Consultation Response from Mike Hibbert,
KC Waste Strategy(Refuse & Recycling)

2024/92168 Land south of, Leak Hall Barn, off Leak Hall Lane, Denby Dale, Huddersfield, HD8 8QU

Outline application for erection of residential development of 13 dwellings

The proposal is for a residential development of 13 dwellings. The applicant has submitted Proposed residential development at Leak Hall Lane, Denby Dale, Dwg Title (24301)2_ Indicative site layout dated May 24.

DRAWING TITLE
VEHICLE TRACKING AND VISIBILITY

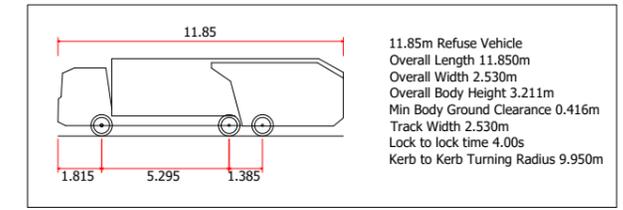
- Swept path analysis must show the manoeuvrability of this vehicle throughout the site, demonstrating the safe passing of other vehicles likely to be using the road – either parked or moving.

- Where turning is necessary, the turning head e.g. in front of Plots 7 and 8 must be demonstrably sufficient for an 11.22m refuse collection vehicle. **Active measures should be taken to prevent parking in the turning head as otherwise an RCV would have a long reverse manoeuvre, that is a recognised safety risk and is not acceptable.**
